Subject: FG/36/26/L

Home Farm House 63 Ferringham Lane, Ferring, BN12 5LL

Application for, building consent for replacement of windows and rear door with timber-framed double-glazed units.

Rev	Date	By	Description
A	18/3/2026	A.K	General Arrangement

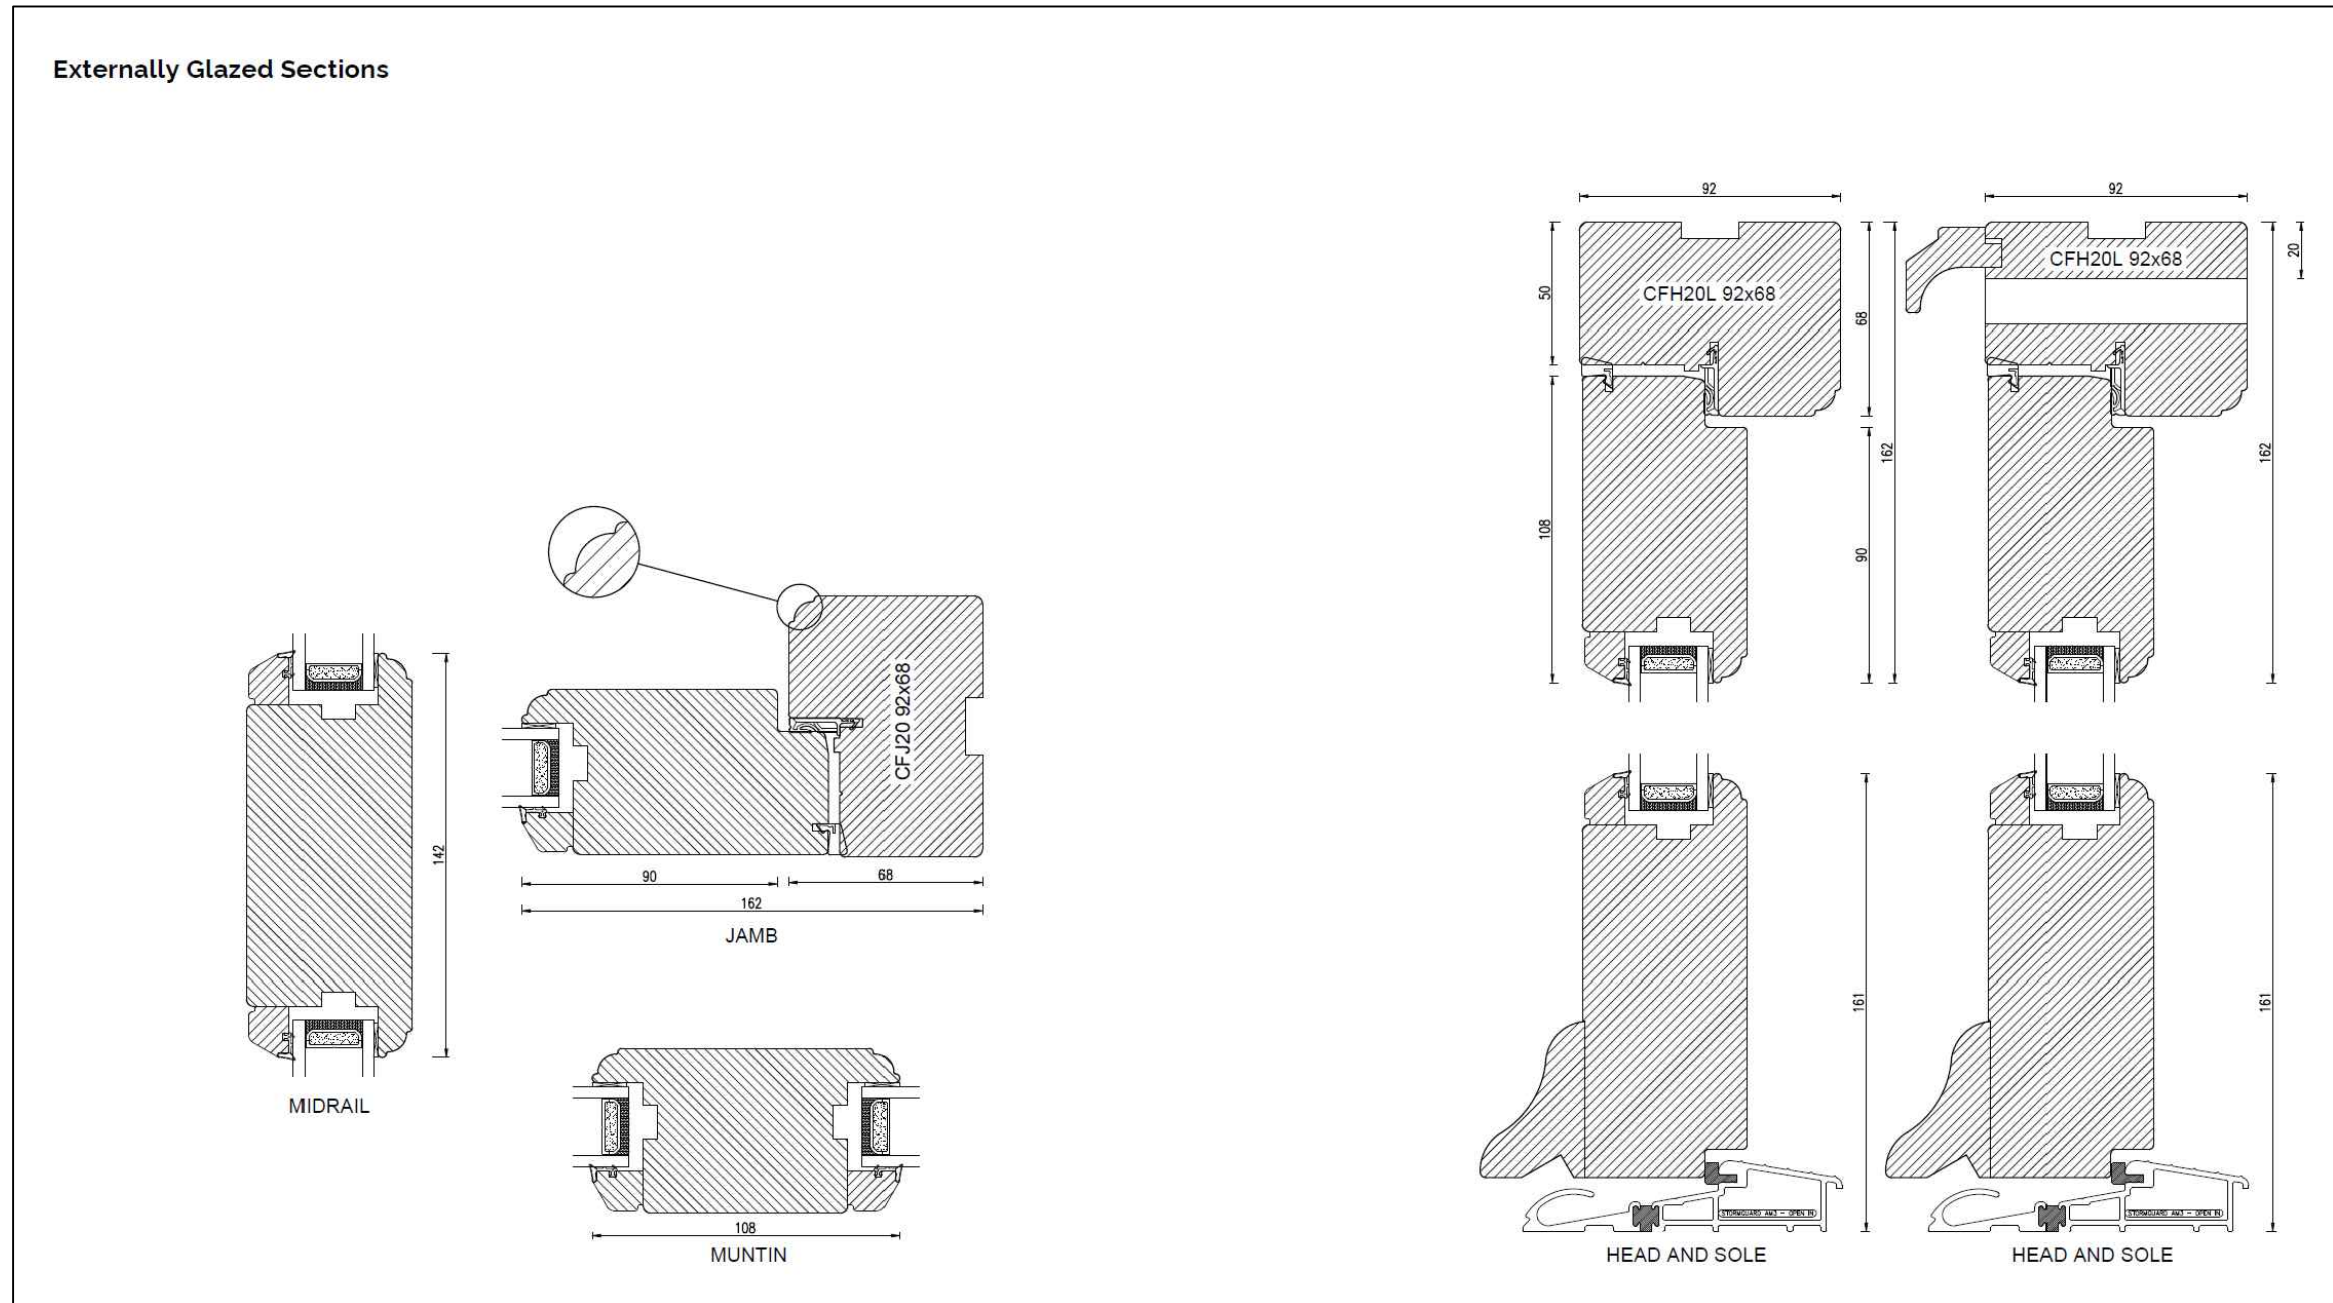
In this case, the proposed use of standard 28mm double-glazed units is not considered appropriate. While the objective of improving thermal performance is acknowledged, such units are inherently incompatible with traditional joinery. Their thickness necessitates increased section sizes and the use of applied glazing bars, resulting in detailing that is fundamentally at odds with traditional construction and leading to a loss of the fine characteristics associated with historic windows.

In respect of the principal elevation, the proposal would result in the loss or substantial alteration of traditional sash windows, which are specifically identified within the statutory list description as retaining intact glazing bars. The introduction of 28mm units would require a fundamental change to the proportions, section sizes and detailing of the sashes, resulting in harm to fabric that contributes directly to the building's significance.

With regard to the rear elevation, it is acknowledged that the existing windows are of modern origin. However, this does not remove the requirement for appropriate design within a listed building. The use of standard 28mm double-glazed units would still result in joinery sections and applied detailing that are visually inconsistent with traditional construction and the established character of the building.

A more appropriate approach would be the use of slim-profile double glazing or other conservation-led solutions that better replicate traditional construction, supported by accurate sectional drawings and detailed joinery specifications. No such solution has been provided. The submitted window details reinforce these concerns, indicating the use of standard double-glazed units with applied astragal bars of approximately 22mm in width, together with modern construction methods such as internal glazing and spiral balances. These are not characteristic of traditional historic joinery, where glazing bars are significantly finer and form an integral structural component of the sash.

While it is suggested that the frames and glazing bars would maintain traditionally slim profiles, this is not supported by the proposed 28mm glazing specification. The physical requirements of such units inevitably result in thicker sections and altered detailing, and the resulting appearance would differ materially from traditional examples.
